Date: 2nd June 2014
Your reference: SSD 5594, SSD 5602 &
PA_0021 MOD4
Our reference: DOC14/86969
Contact: Liz Mazzer 68835335

RE: Springvale Mine Extension Project (SSD 5594), Angus Place Mine Extension Project (SSD 5602) and Angus Place Development Continuity Project (PA_0021 Modification 4)

OEH review

Springvale Mine Extension Project (SSD 5594)
Angus Place Mine Extension Project (SSD 5602)
Angus Place Development Continuity Project (PA_0021 Modification 4)

DATE: 2-Apr-2014	SCALE: 1:40000	DRAWING No: MSEC593-07	Rev No C
---------------------	-------------------	---------------------------	-------------

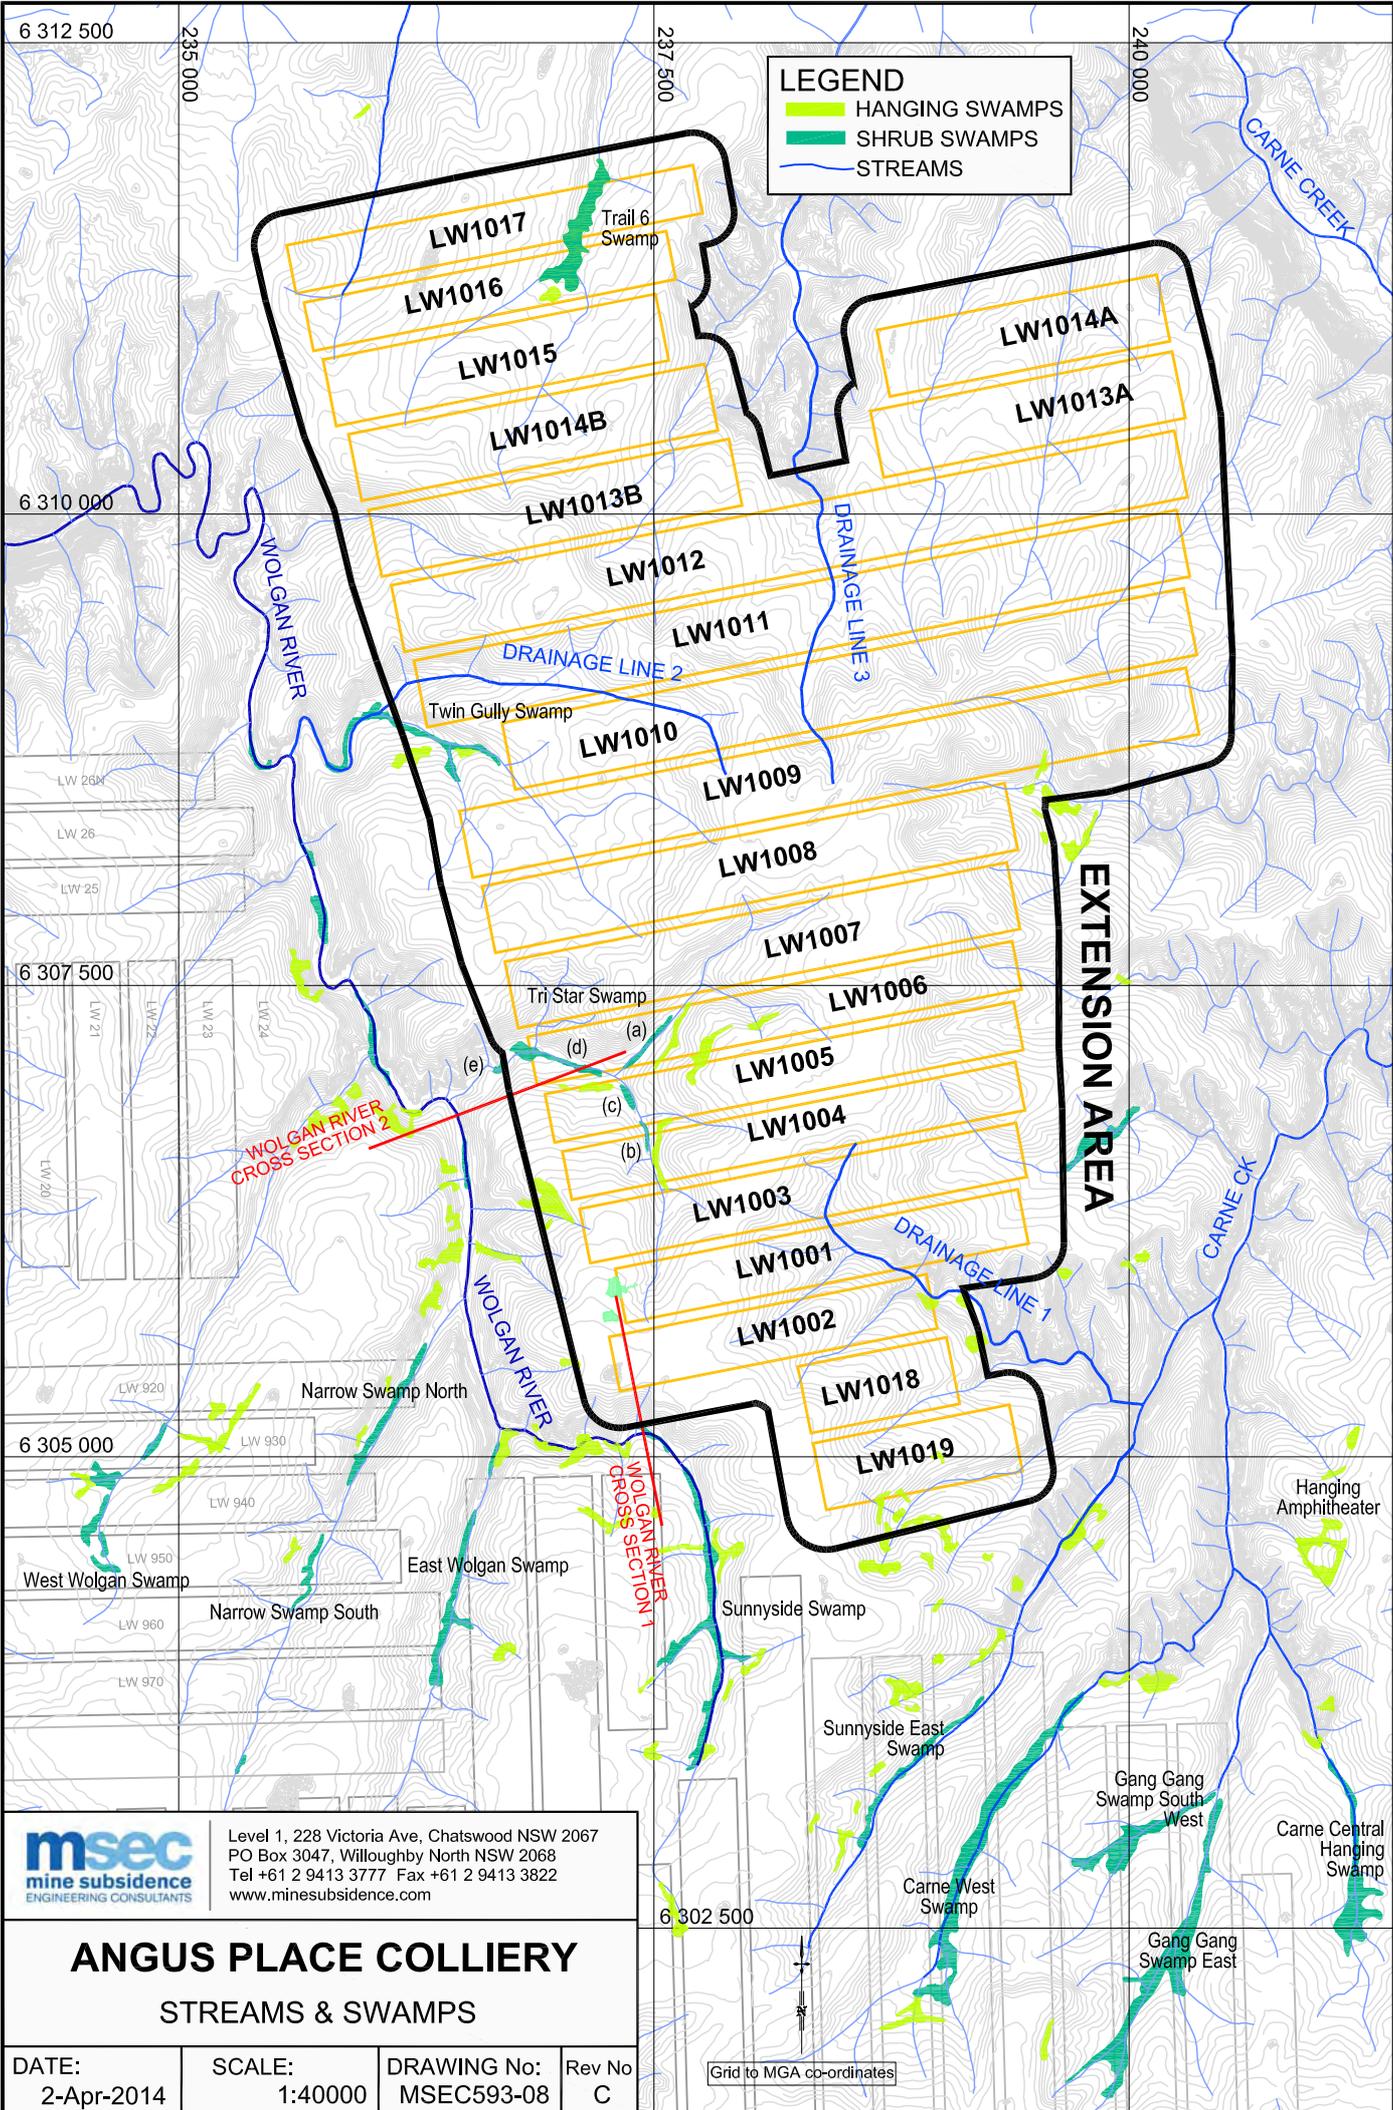
Type 1 and Type 2 geological structure zones have been identified within the Extension Area, which are shown in Drawing No. MSEC593-07. It is expected, that locally increased subsidence and compressive strains will be observed in these locations.

Given that stresses will be similar to previously extracted longwalls, OEH believes that impacts will not necessarily be lower under the current mine plans than what has been demonstrated to occur over existing operations. While Springvale longwalls have been reduced to a width of 261m, the EIS fails to point out that impacts to one NPSS (ie Kangaroo Creek Swamp) occurred as a result of earlier longwalls that were 262m wide (LW940). Since the longwalls at Angus Place have actually increased their width by over 18% (to 360m), there is a significant potential for increased impacts as a result of the Angus Place proposed longwall layout. OEH notes that the predictions lines for Angus Place (A1 & A2) appear to miss the majority of incised drainage lines and steep slopes that lie above the proposed Angus Place mine.
